WEST SUSSEX COUNTY COUNCIL CONSULTATION

TO:	Arun District Council FAO:David Easton
FROM:	WSCC - Highways Authority
DATE:	16 July 2019
LOCATION:	Land north of Hook Lane, Pagham
SUBJECT:	P/30/19/OUT Outline application with some matters reserved for the construction of up to 300 No. new homes, a care home of up to 80 beds, D1 uses of up to 4,000 sqm including a 2 form entry primary school, the formation of new means of access onto Hook Lane & Pagham Road, new pedestrian & cycle links, laying out of open space, new strategic landscaping, habitat creation, drainage features & associated ground works & infrastructure. This application may affect the setting of a listed building & is a Departure from the Development Plan (resubmission following P/6/17/OUT).
DATE OF SITE VISIT:	N/a
RECOMMENDATION:	No Objection
S106 REQUIREMENTS:	Proposed improvement works to the B2166/Vinnetrow Road roundabout as shown on drawing number 1616/14 or any other such scheme as agreed with WSCC*. These works should be completed by the occupation of the 100th dwelling. Contribution of £114,184 towards improvements to Pagham Road/B2166 Lower Bognor Road junction or any other works that would mitigate the increas

NOTES:
 Reproduced by Stanfords by permission of Ordnance Survey®
 on behalf of the Controller of Her Majesty's Stationery Office.
 © Crown copyright and database rights 2016 OS Licence
 100035409.

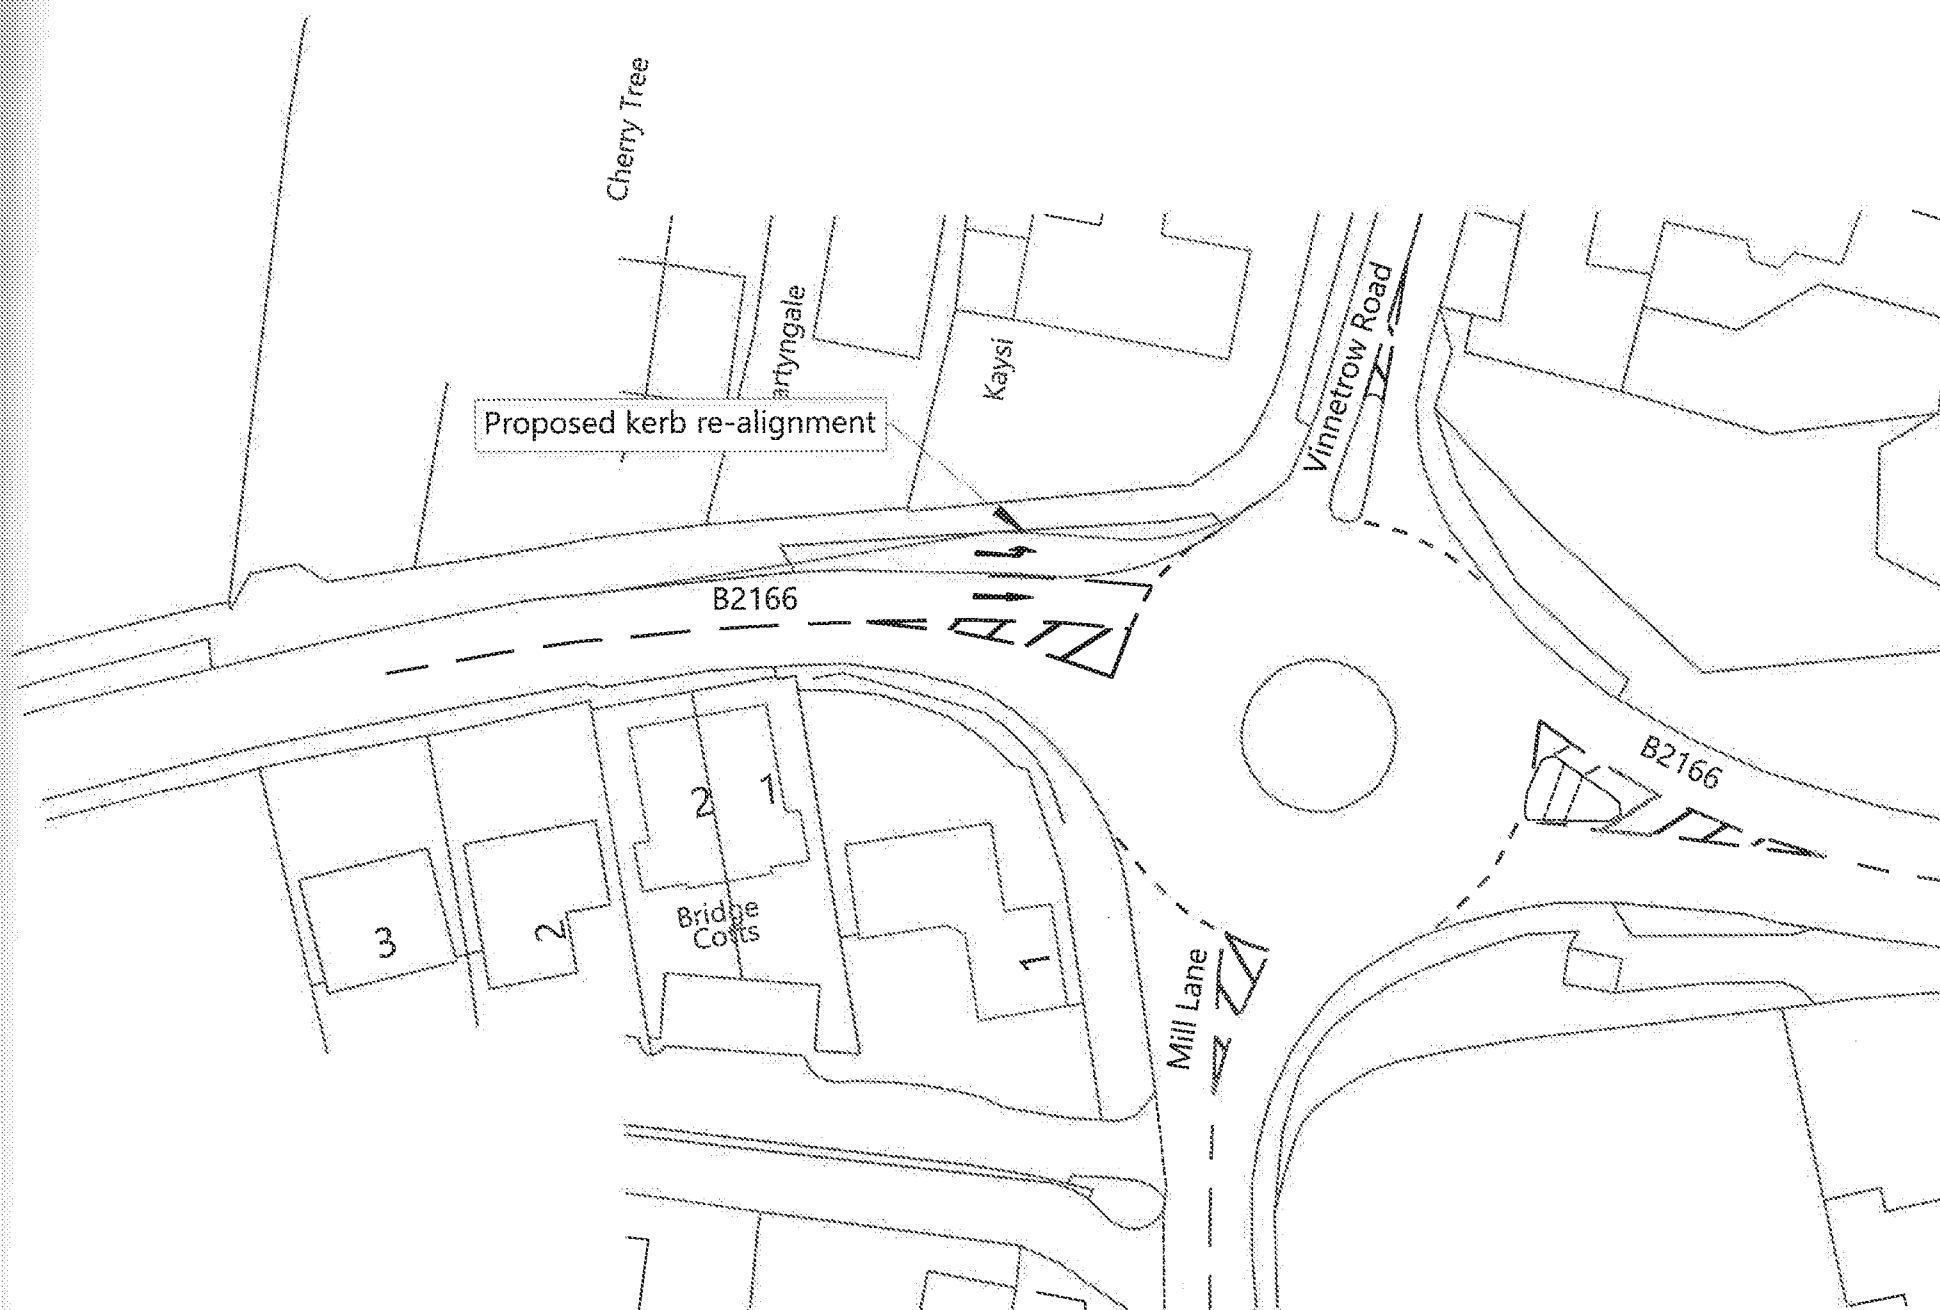
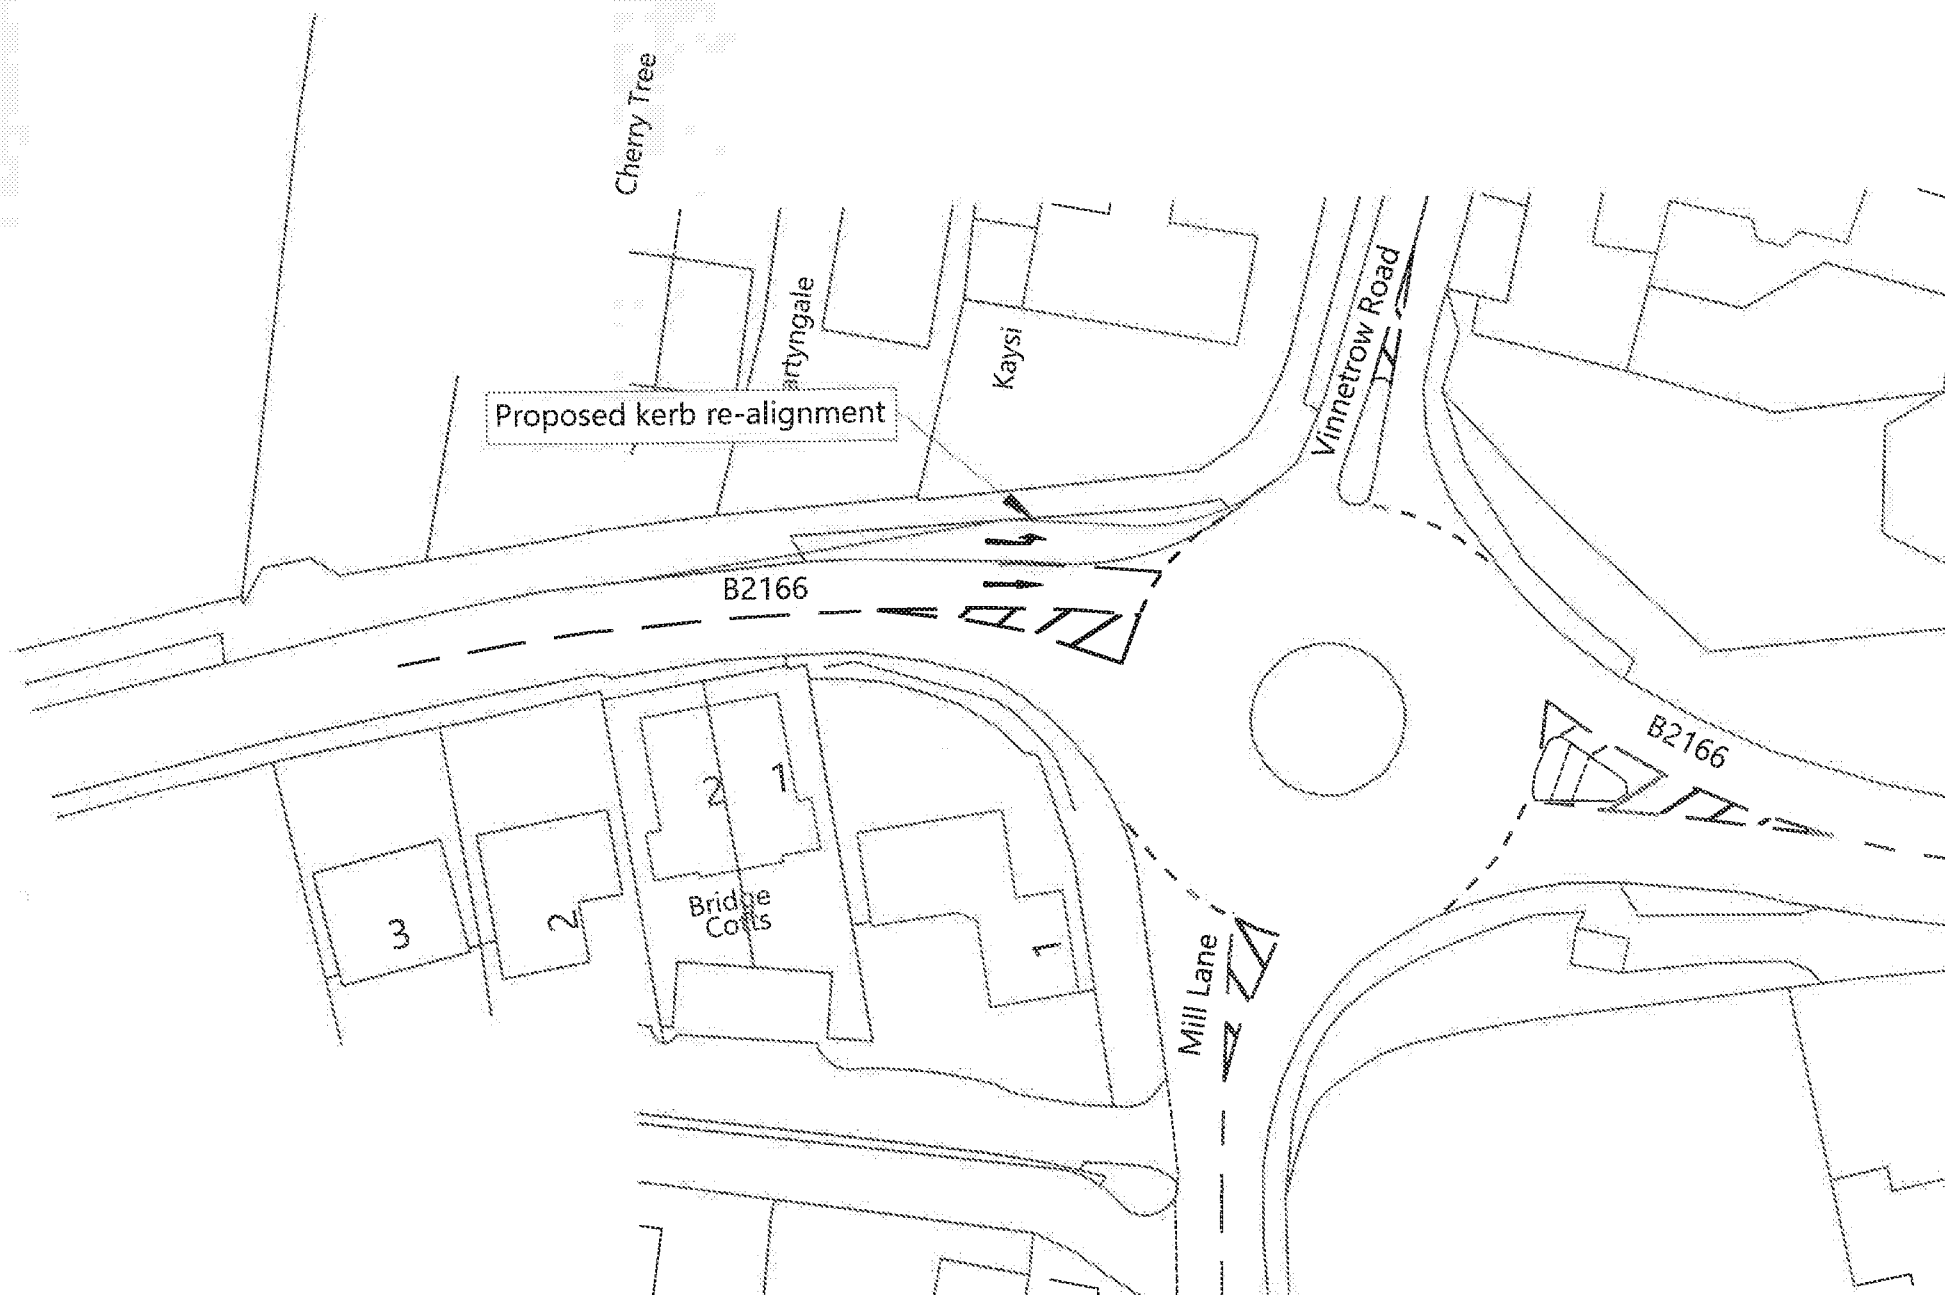
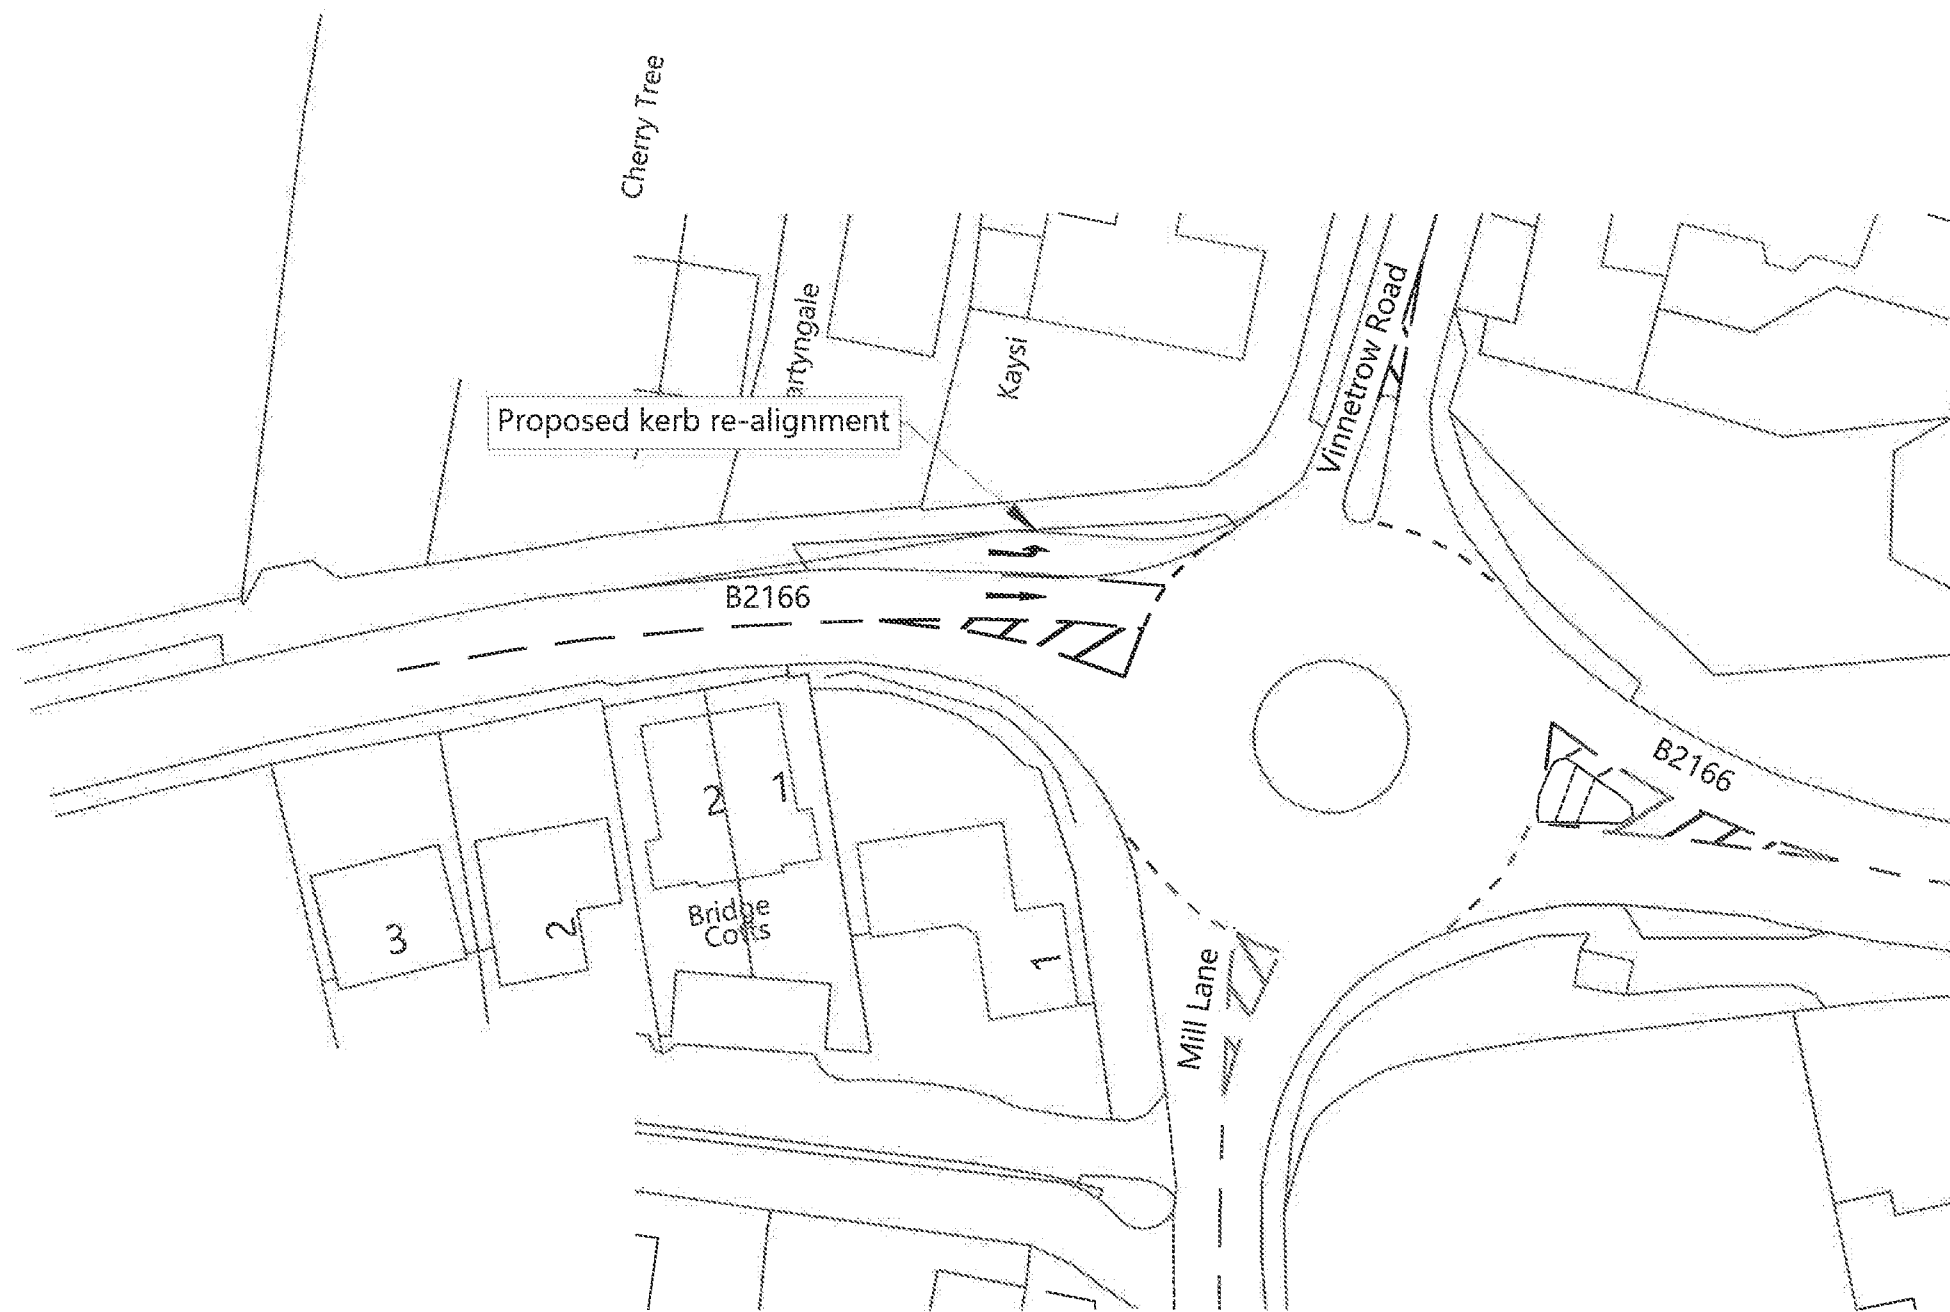
- Proposed improvement works to the B2166/Vinnetrow Road roundabout as shown on drawing number 1616/14 or any other such scheme as agreed with WSCC*. These works should be completed by the occupation of the 100th dwelling.
